**ADC Planning Consultation
Conservation/Design Officer Response**

Application Number	F/29/17/PL
Address	Waterbury House Ford Road Ford BN18 0BH
Description	Construction of 5 No. 1 bedroom flats (C2 Residential Institutions) together with ancillary accommodation. This application affects the setting of a Listed Building & is a Departure from the Development Plan.
Case Officer	<u>Mrs A Gardner</u>
Date	28 th November 2017

Proposed West Elevation

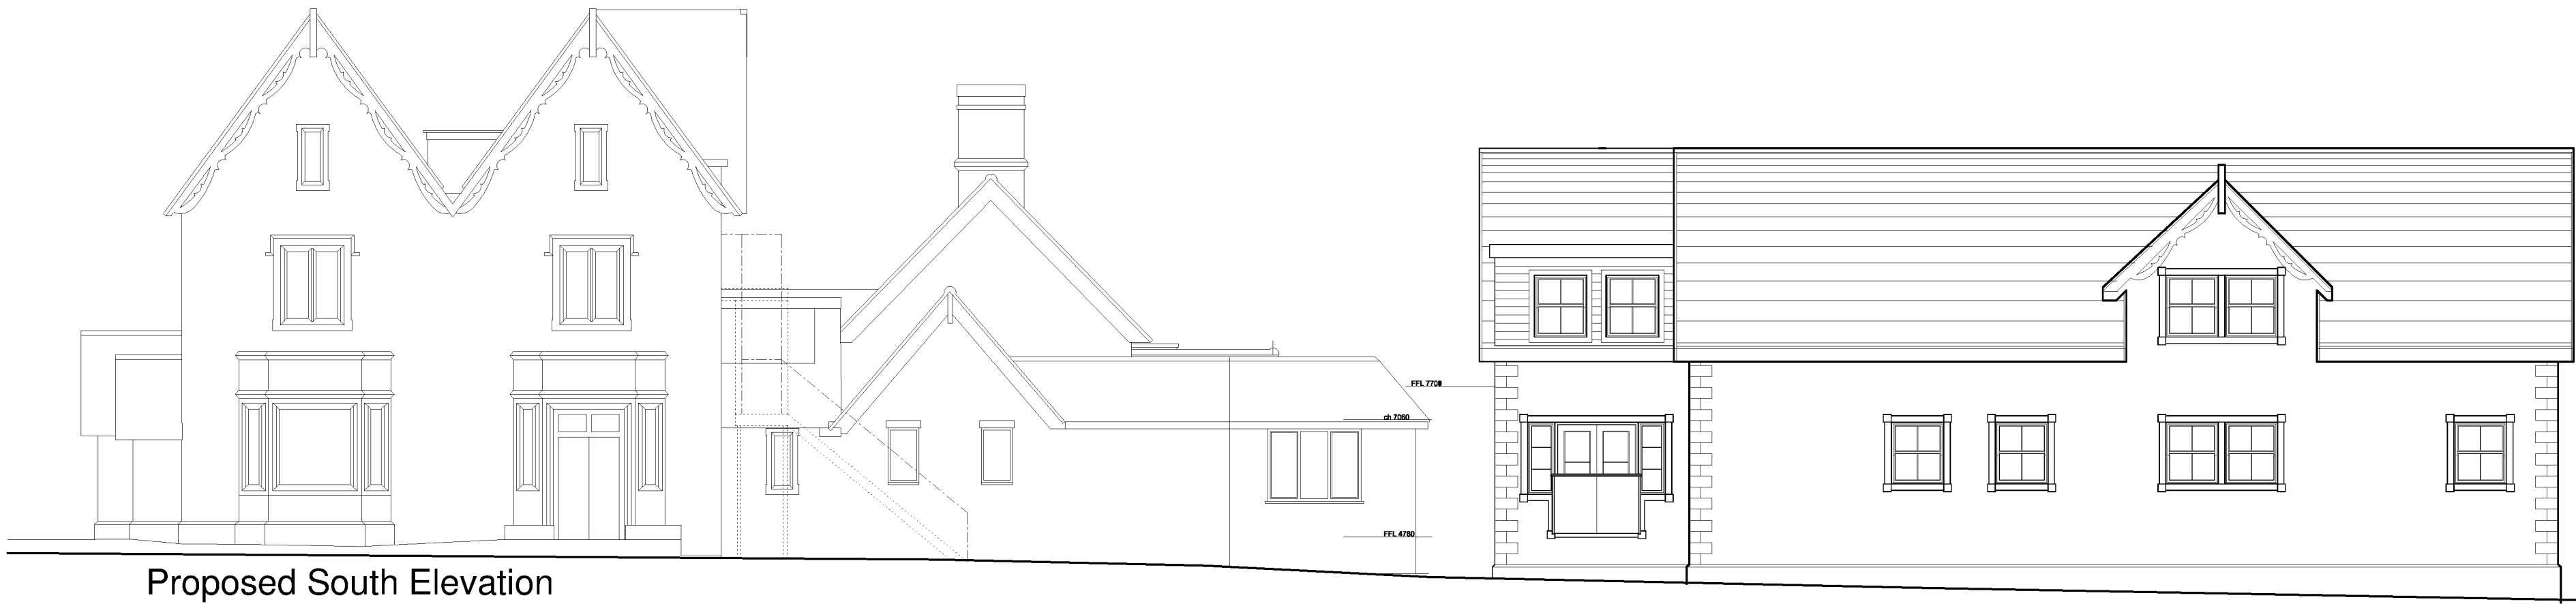
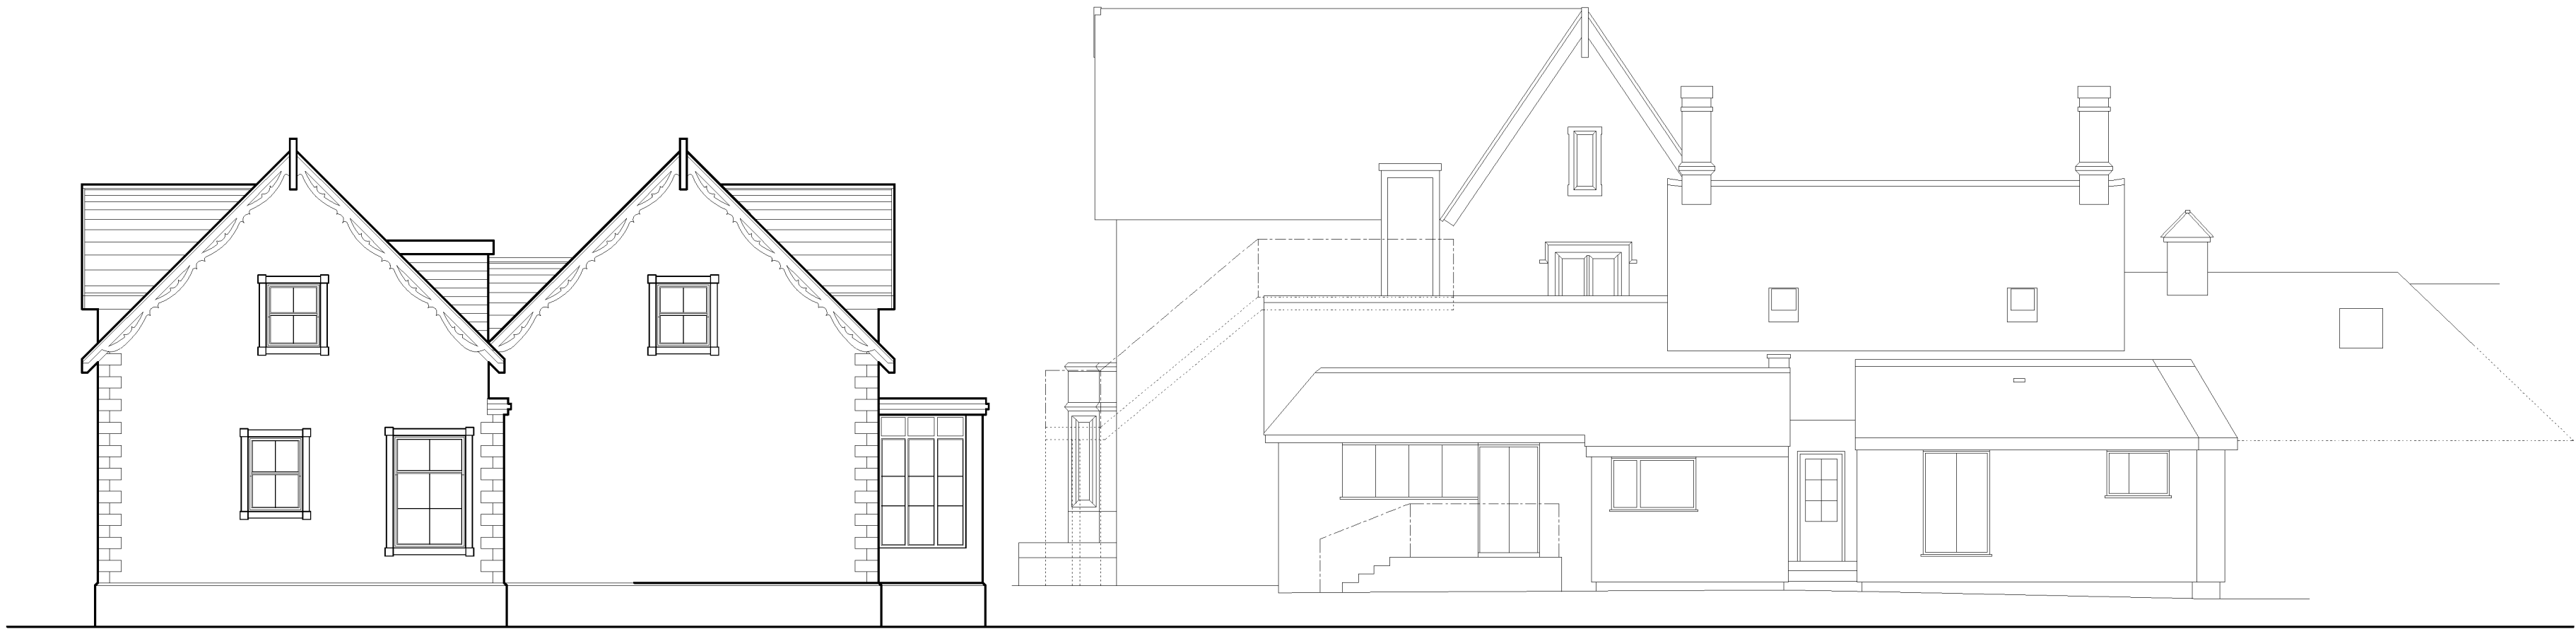
The proposal is 1.5 storey, with a bulky roofscape, comprising multiple dormer windows, with a max ridge height of 16,000mm approx. The material palette as described of brick, tile and painted wood joinery details could be in principle acceptable, subject to detail, although there are large areas of glazed guarding visible to the west and South Elevations.

It is considered that the overall mass of the building as a whole, the dominant roofscape and the proximity of the proposed development would adversely affect the setting of the listed building.
